From: Anita Gardner
Sent: 10 July 2018 17:20
To: Planning.Responses
Subject: FW: M/64/18/DOC172 Elmer Road

Engineers Responses Relating to Condition 7- surface water drainage

CLIENT:	Farndell Builders Ltd
JOB ID:	172 Elmer Road
SCOPE OF WORK:	Soakaway Design
DESIGN CODES AND REFERENCES:	BRE 365
SOFTWARE:	MS EXCEL
SUB-SOIL/ FOUNDATION DATA:	N/A

Percolation test data supplied

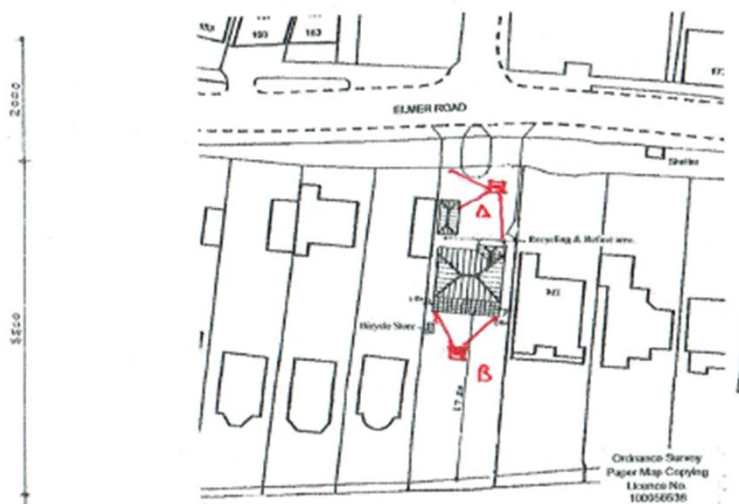
- I am a little confused as to how the infiltration rates have changed between submissions. In the previous submission the lowest rate was $6.07 \times 10^{-6} \text{ms}^{-1}$. Now it has changed to $5.46 \times 10^{-5} \text{ms}^{-1}$. Please can the applicant explain this discrepancy?
The original infiltration rate was incorrectly calculated and based on a different field test. The actual test was a percolation test with the results reported in Vp (mm/sec), the test method and the derivation of infiltration rate is detailed in the calculation together with the test results. And the worst infiltration value has been used which is very conservative as the infiltration rate measured at the location of the soakaway is an order of magnitude greater.

It should also be noted that the lowest recorded infiltration rate should be used, not the average. I.e. please use $6.07 \times 10^{-6} \text{ms}^{-1}$ – Test hole A has the lowest infiltration level. This result has been used for the new calcs.
